**WELWYN HATFIELD COUNCIL – DEVELOPMENT CONTROL**  
**DELEGATED REPORT**

<b>APPLICATION No:</b>	<b>S6/2008/2240/FP</b>
------------------------	------------------------

The proposed development would comprise a two-storey side and rear extension. The proposal would be set back from the front elevation and have a width of 1.7m from the side elevation. The extension would have a depth of 3.0m beyond the rear elevation and a width of 7.1m, which would result in the extension straddling the boundary with the adjoining dwelling. The proposed extension would have a pitched roof that would adjoin the main roof but have a separate ridge to a maximum height of 8.2m (measured from the rear).

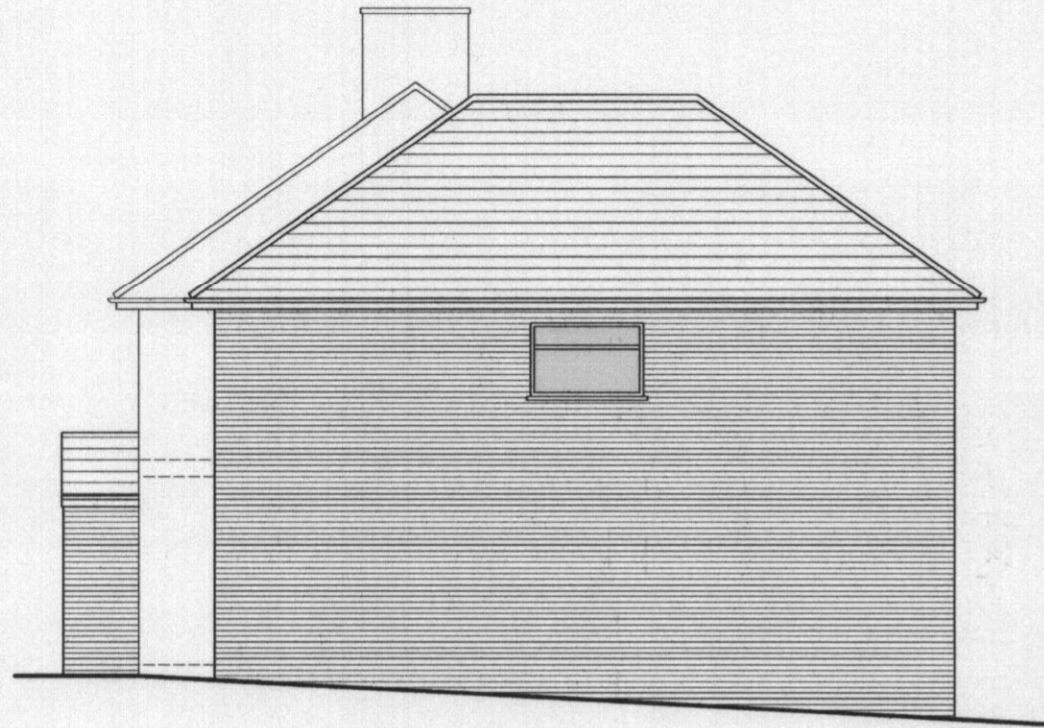
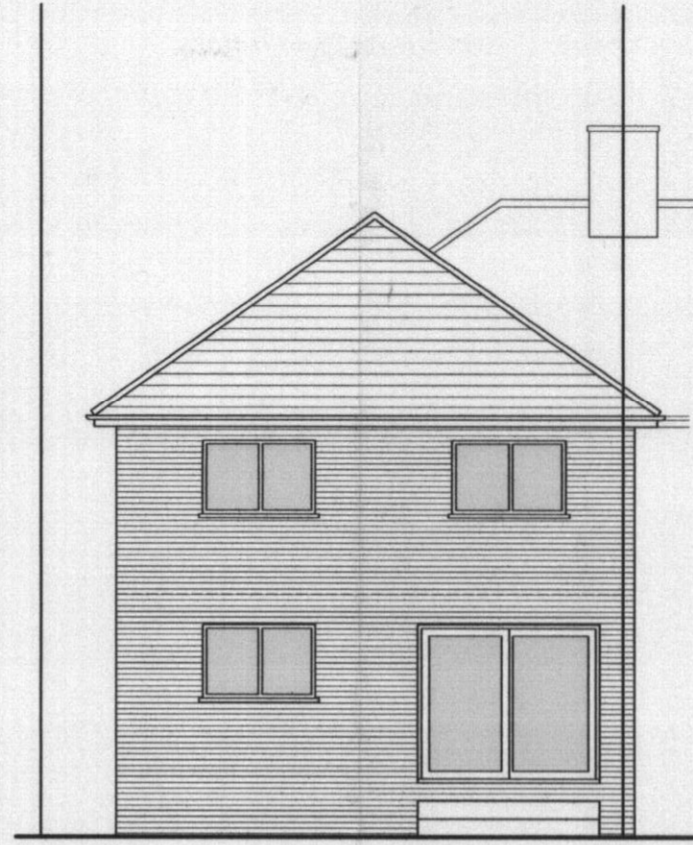
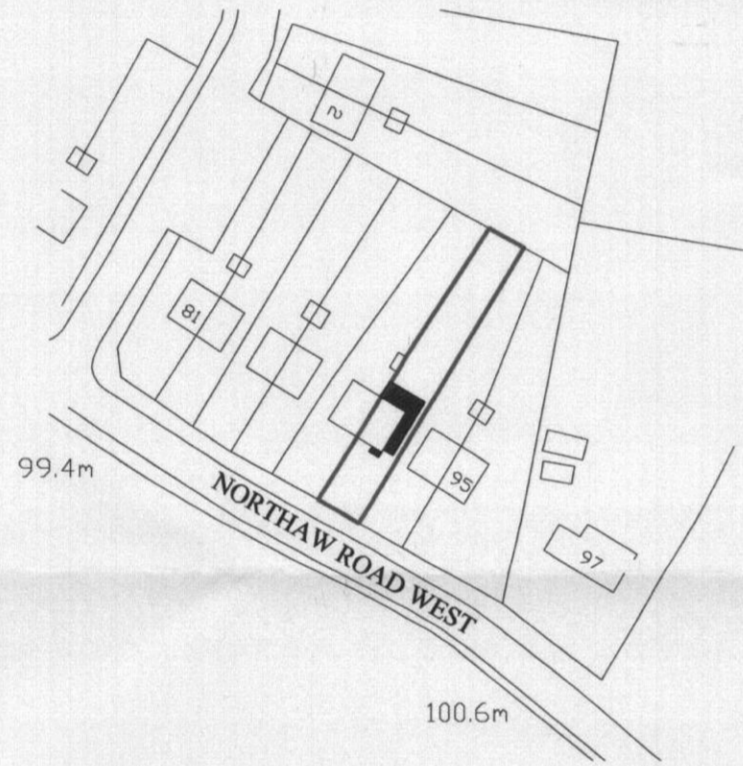
The proposed development would also create a two storey side and rear extension, which would be visible from the front of the dwelling and the surrounding public areas. This addition would be set back from the front elevation, but has not been designed to appear clearly subordinate to the original dwelling. Due to the height, depth and separate roof form of the proposal, it would appear bulky and prominent within the streetscene. The resultant dwelling would have an incongruous appearance and from some angles the proposed roof would appear awkward and not subordinate to the original building.

A visual assessment of the proposed development shows that the proposed extensions would be substantial in terms of height, mass and bulk. The proposed two storey addition would not appear subordinate to the original dwelling and the ridge height would be similar to that of the main roof. The proposed roof would not appear low from the surrounding areas. The proposed flank elevation would be two storey and significantly deeper than the flank elevation of the main dwelling. The size of the flank elevation combined with the ridge that would be above and the existing dwelling would cumulatively result in a substantial and dominant dwelling. The resultant dwelling would clearly be disproportionate to the original and would have an unacceptable impact upon the openness of the Metropolitan Green Belt.

2. The proposed two storey extension, by virtue of its height, depth and proximity to the western boundary, would result in a loss of light and have an overbearing impact upon the occupants of the adjoining dwelling to the west (number 89). This would result in an adverse loss of residential amenity to the occupants, which would be contrary to Policy D1 of the Welwyn Hatfield District Plan 2005.

3. The proposed two storey extension, by virtue of its size, design and bulk would appear out of place and not reflect the character of the existing dwelling. The design of the proposed two storey extensions would not achieve an appropriate standard and would not be subordinate to the original and existing dwelling. The resultant dwelling would appear overly prominent and incongruous within the streetscene and have a detrimental impact upon the character and appearance of the locality. This

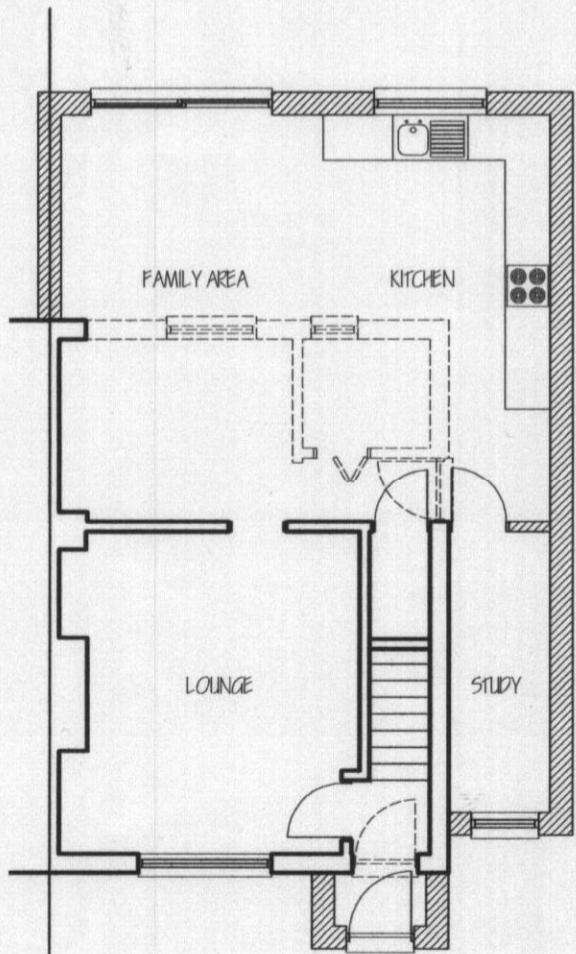
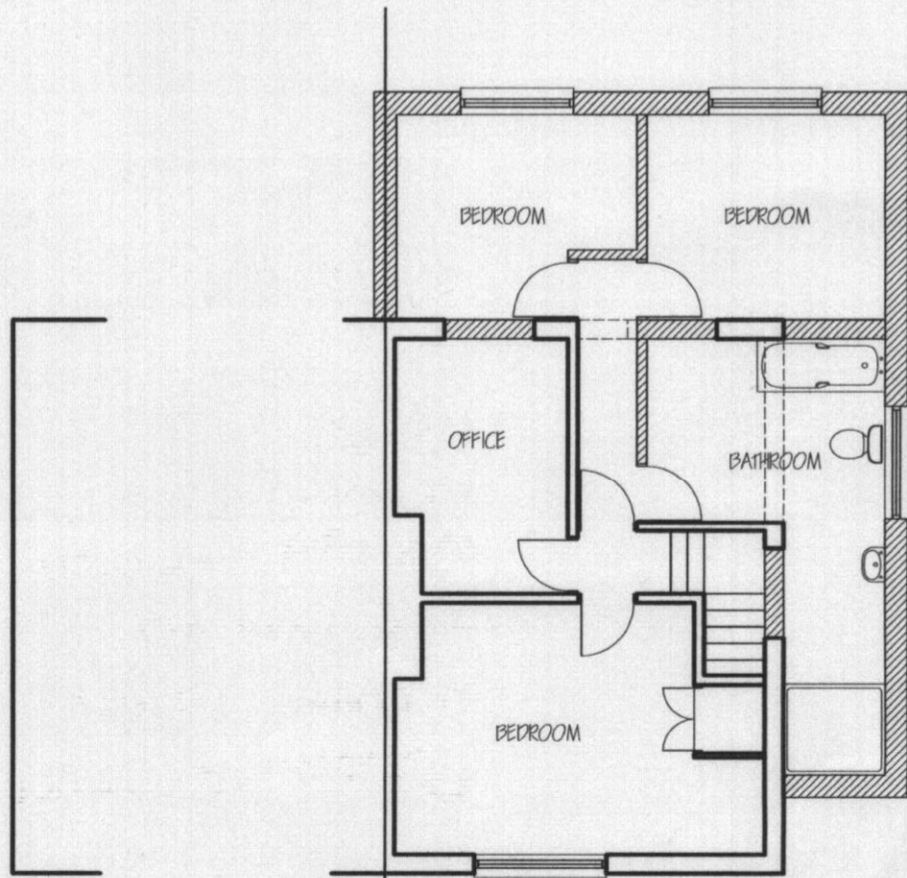
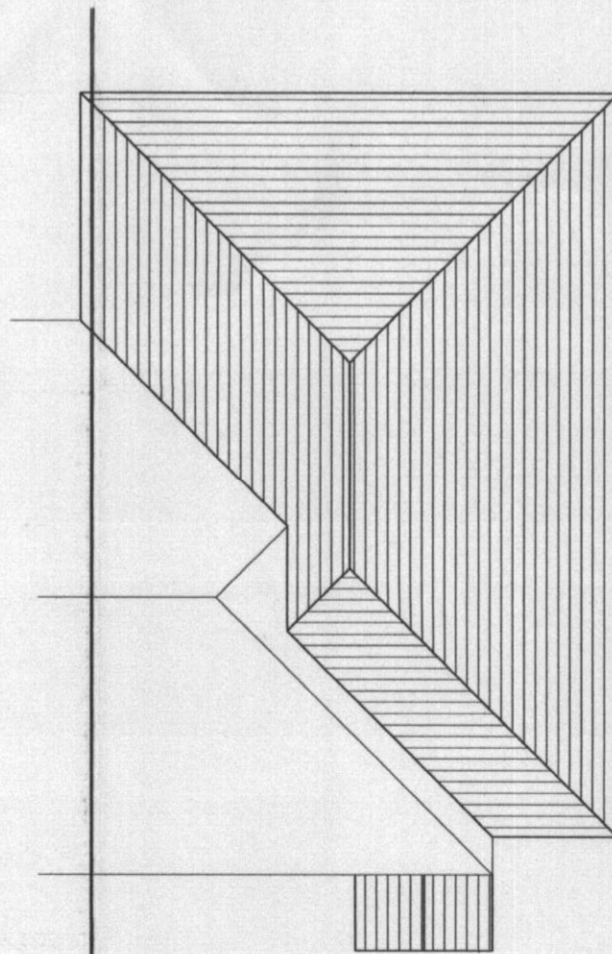
There is a discrepancy in the plans. The ground floor plan, roof plan, site plan (1:1250 and location plan (1:500) have been illustrated to show the proposed side extension set back from the front elevation by 0.5m, whilst the first floor plan and side elevation show a distance of 1m.
